From: Nathan Everett <Nathan.Everett@fire.nsw.gov.au>
Sent: Tuesday, 16 March 2021 12:11 PM
To: Stephen Richardson
Cc: Brian Hanley (InTouch); john.studdert@manildra.com.au; John Hawes; Fire Safety
Subject: RE: Request for Requirements for Preparation of Statements of Environmental Effects - Proposed Mods 21, 22 and 23, Shoalhaven Starches Expansion Project (MP06_0228)

Shoalhaven Starches have submitted requests to the Department of Planning, Industry and Environment (DPIE) seeking their requirements for the preparation of Statements of Environmental Effects in relation to three (3) separate Modification Proposals relating to the Shoalhaven Starches Expansion Project (MP06_0228). In addition to seeking DPIE's requirements for the preparation of these Modification Application documents, we also seek to consult with Fire & Rescue NSW to ascertain any issues that Fire & Rescue NSW considers should be considered as part of the preparation of these Modification Applications. The purpose of this email is to formally consult and seek any issues that Fire & Rescue NSW considers should be considered as part of the preparation of these separate Modification Applications.

From: [Development

Figure 5: Site Plan showing location of approved and proposed gas fired co-generation plant and location of coal fired co-generation plan which is to be replaced

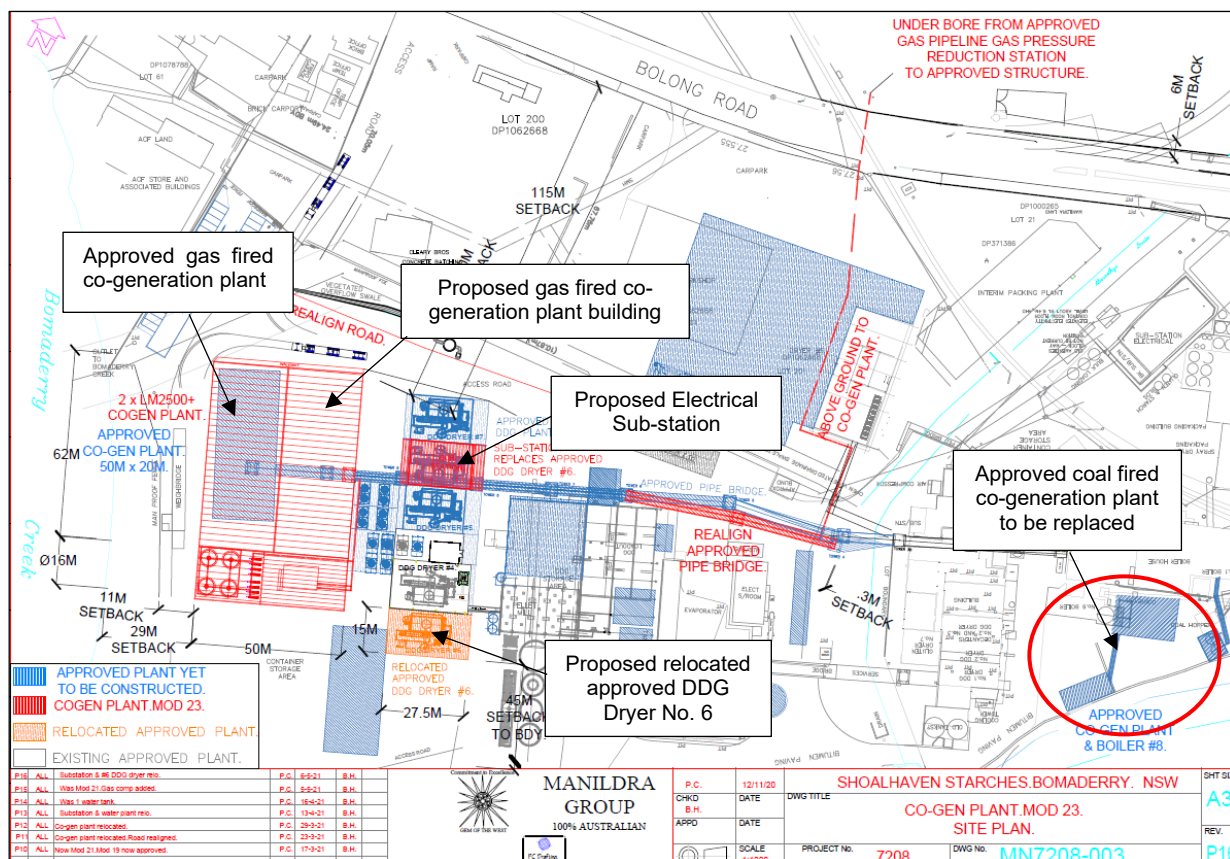
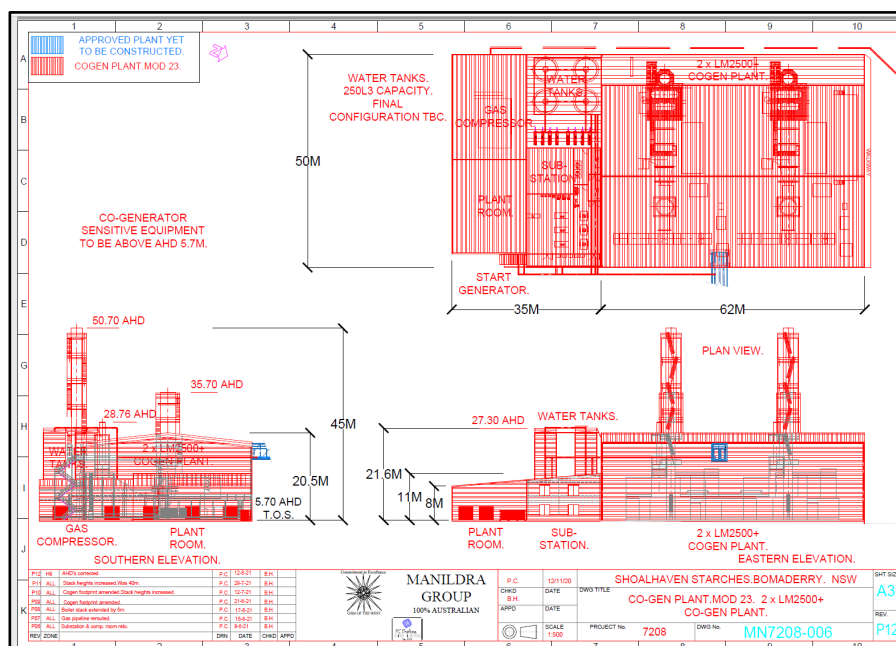
1. No actual works in the road reserve are anticipated. Underbore of Bolong Road to connect natural gas pipeline.

2. A hydraulic impact assessment is required to ensure that the propose development will not adversely increase flood hazard and damage to other properties or adversely affect flood behaviour for a 5% AEP up to the PMF scenario. Besides, flood related development controls (Chapter G9, Shoalhaven Development Control Plan 2014) need to be assessed appropriately.
